**SUPPLEMENTARY INFORMATION**

Site Name	Land at Tittenhurst Park	Site Address	Land southwest of Tittenhurst Park, London Road, Ascot, SL5 0PP
NGR	E: 494966 N: 168167		
Site Ref Number	95980	Site Type	Macro

Provided by: <a href="http://www.entrust-services.com">www.entrust-services.com</a>	<b>Surveyed by:</b> Neil Gates
Unit 4 Century Building, Liverpool, L3 4BJ T: 01925 407 074	<b>Created by:</b> Ignatius Lo
	<b>Approved by:</b> Kieran Tarpey

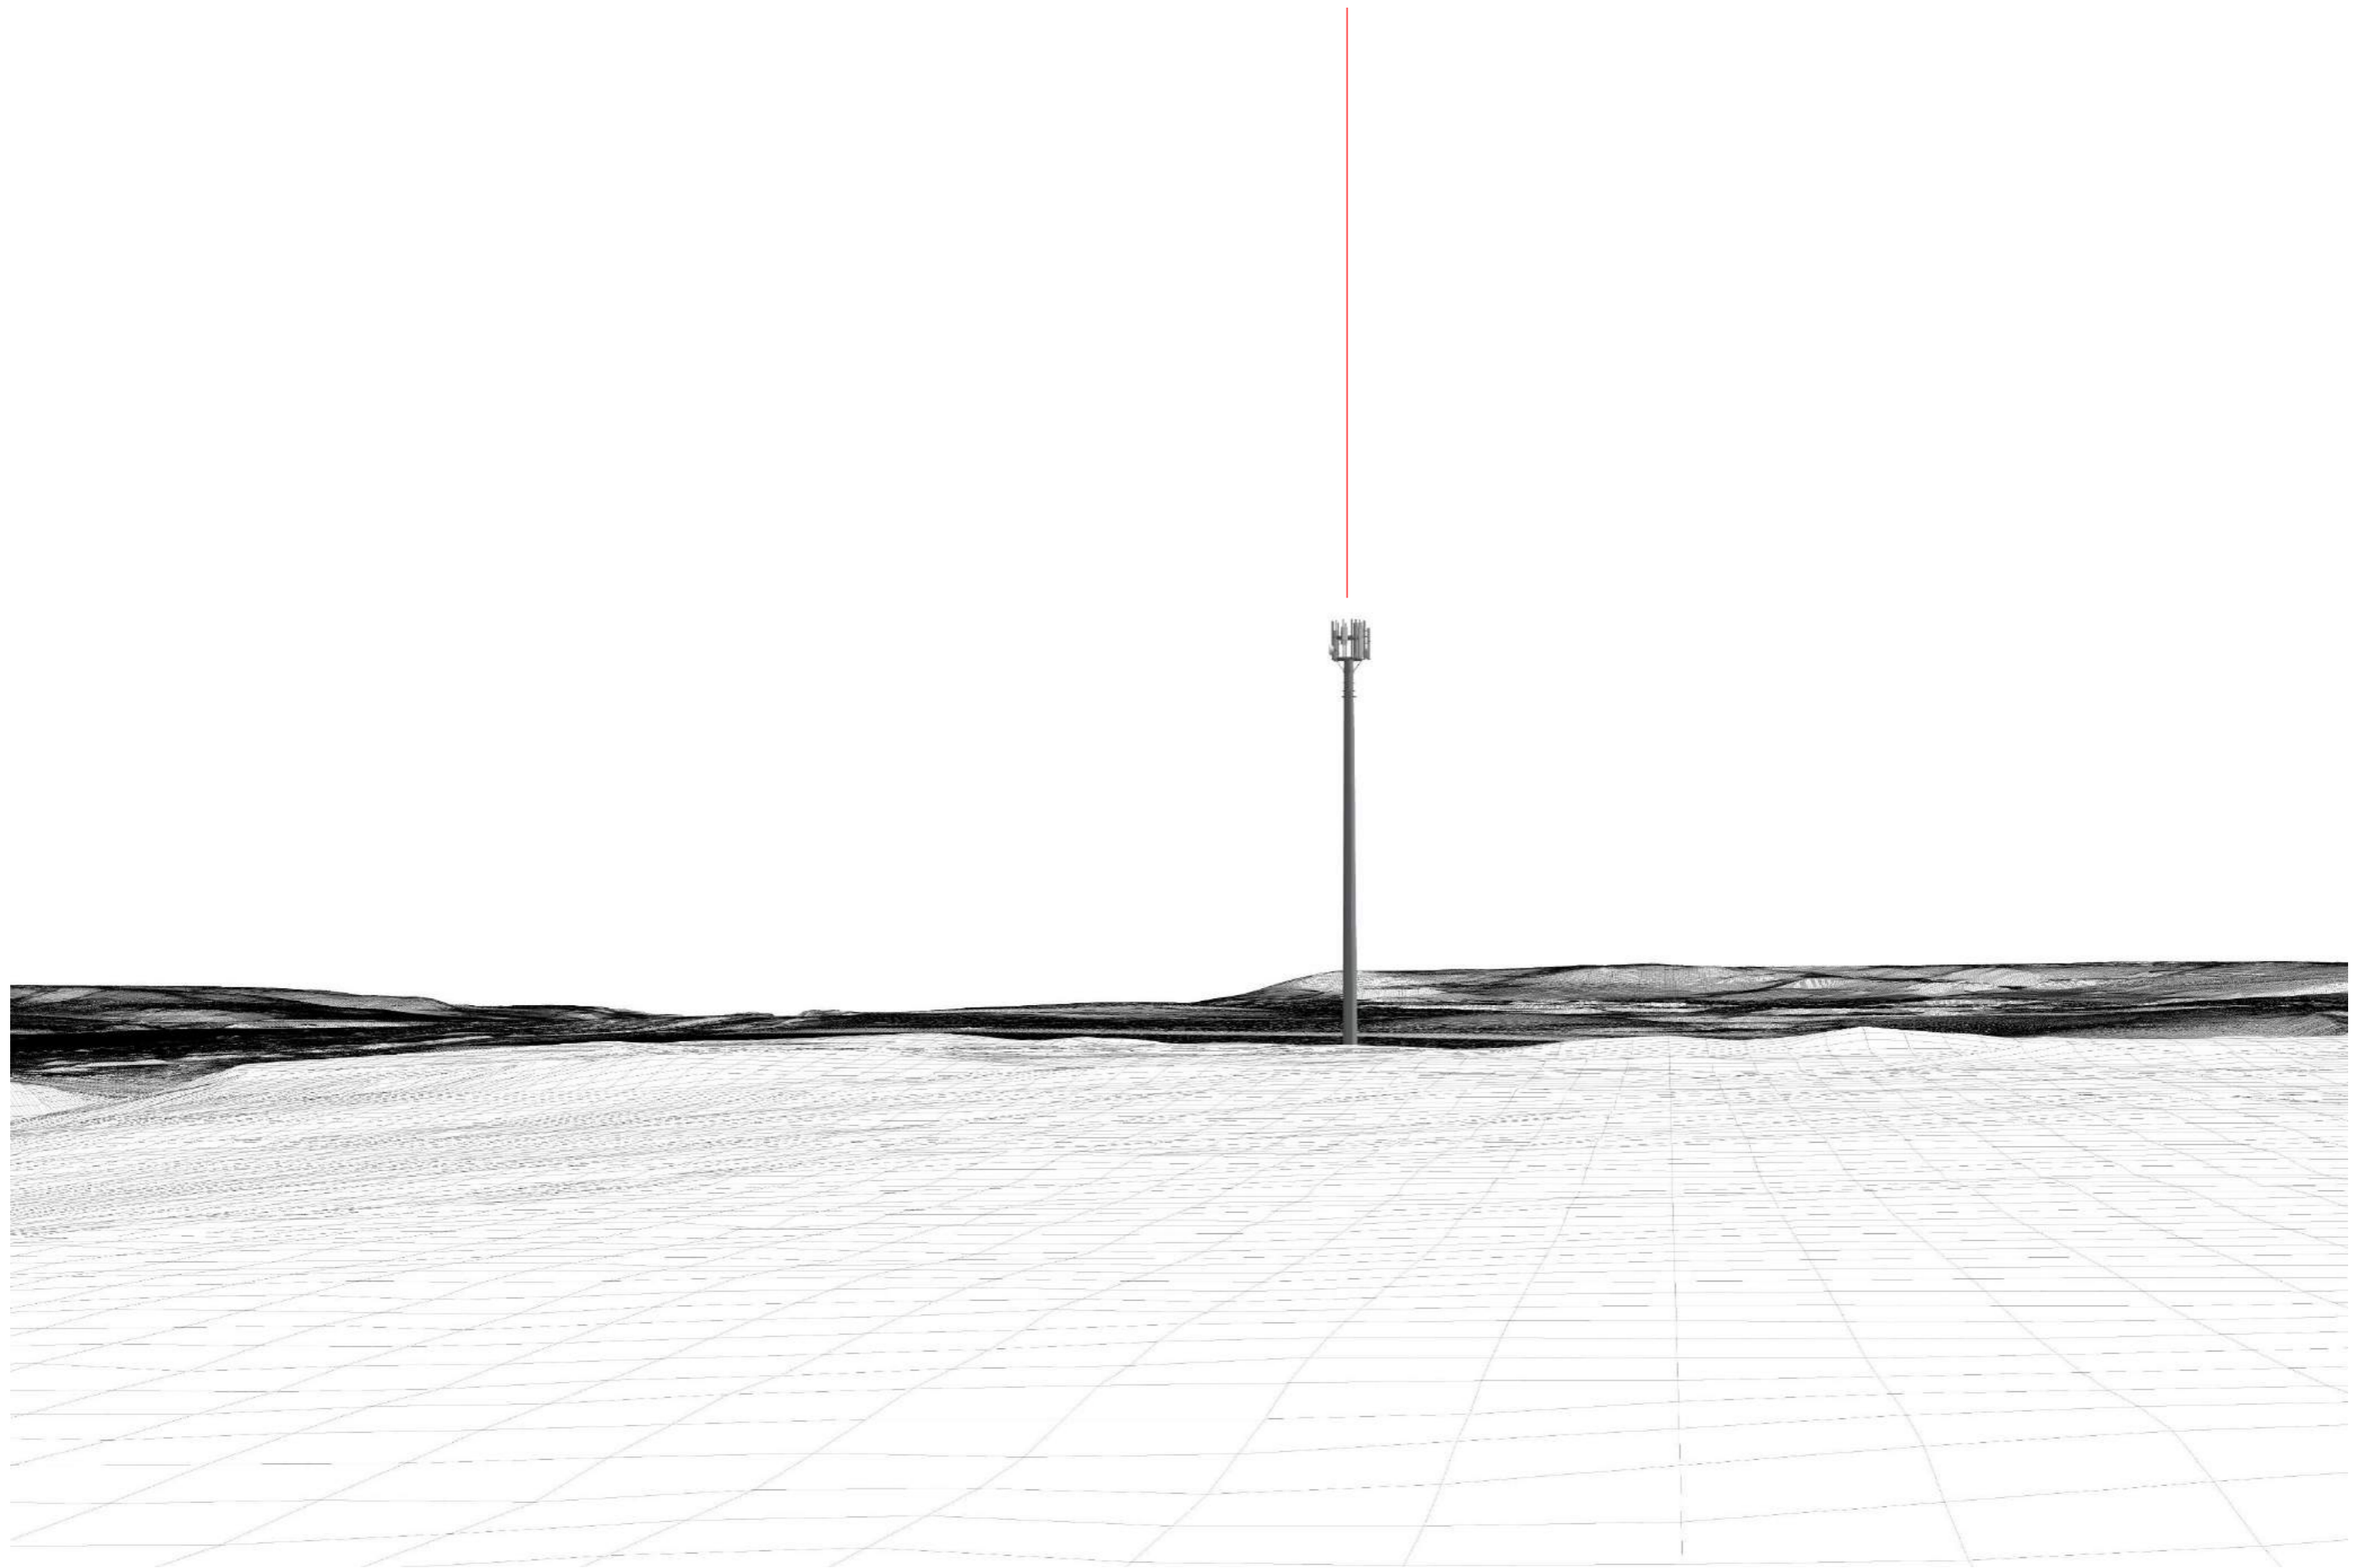
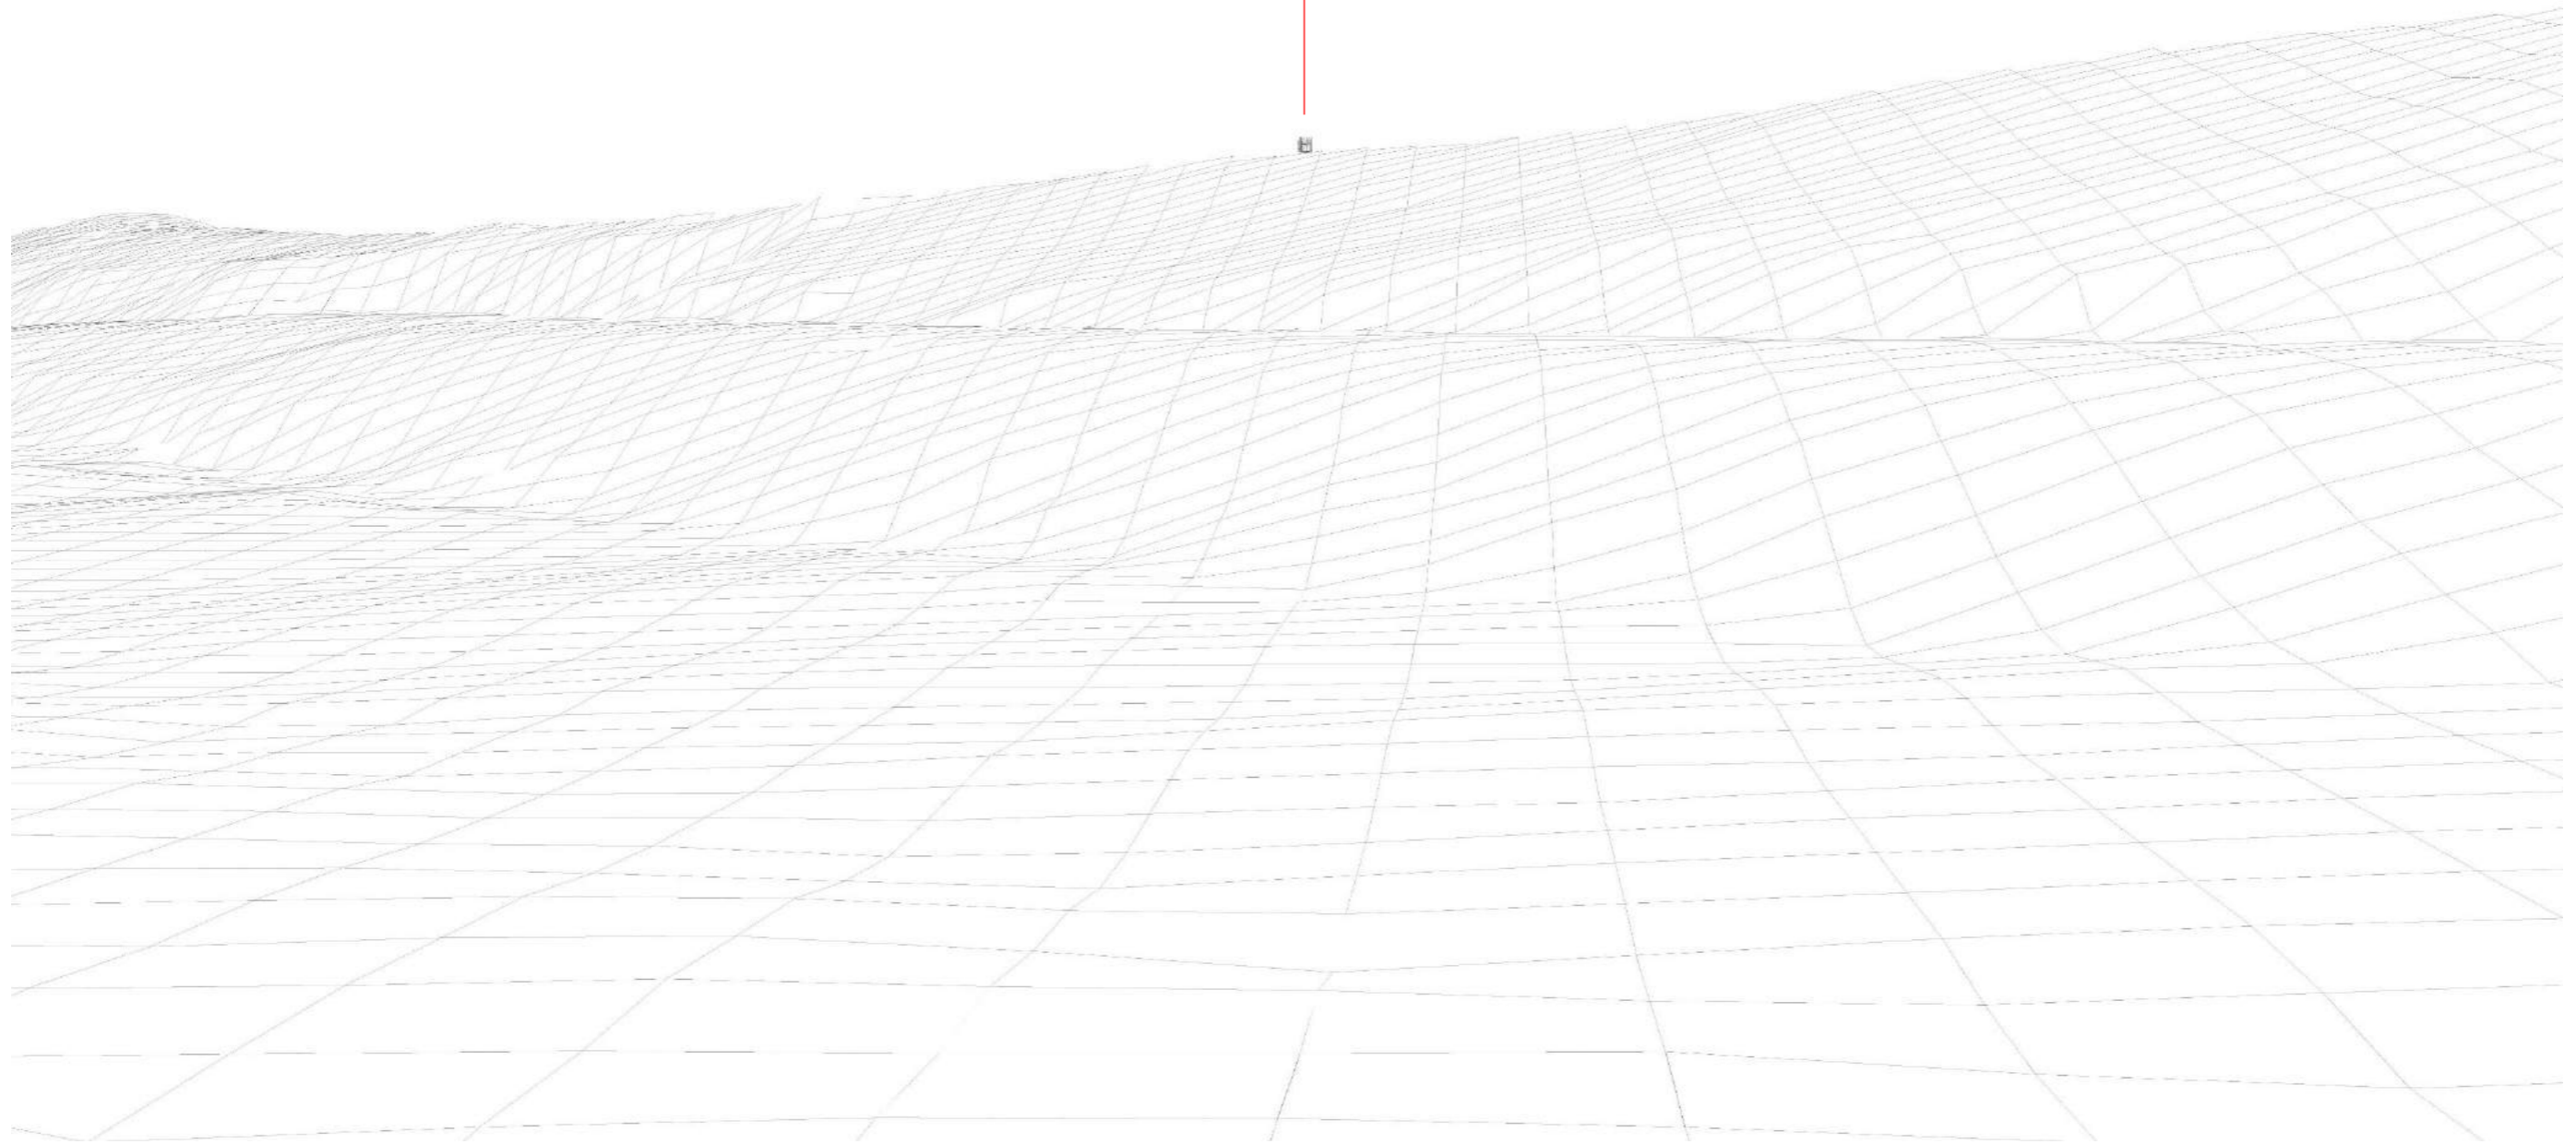
*“The impact on local character, landscape and heritage assets will be a key consideration. I note the intention to submit an LVIA but in the absence of that information we are unable to give any detailed advice on the likely acceptability of the scheme. There are some comments regarding the precedent set by the existing mast and the screening of the trees but given the proposed height of the mast I would not consider that the existing mast justifies this nor that surrounding trees would offer substantial screening. Based on information seen to date I would be concerned at the visual impact of the mast in this location.”*

Applicant Response – Given the site is located within a Greenbelt, a Photo Montage Report has been included from surrounding viewpoints. The existing mast sets the precedent that telecoms infrastructure is generally acceptable at this location in comparison to other sensitive locations in this area. Regarding the mature trees in this area, as can be seen from the Panoramic Survey Report enclosed in this application, the trees measure between 10m-30m which means there is sufficient screening for long range views when taking into account other natural vertical elements within the landscape. As demonstrated within the enclosed Photo Montage Report, visuals from public vantage points are mitigated as far as possible and the proposal is screened by trees from these viewpoints. Therefore, the visual impact from long range views is expected to be minimal on this area even given the height of 30m proposed.
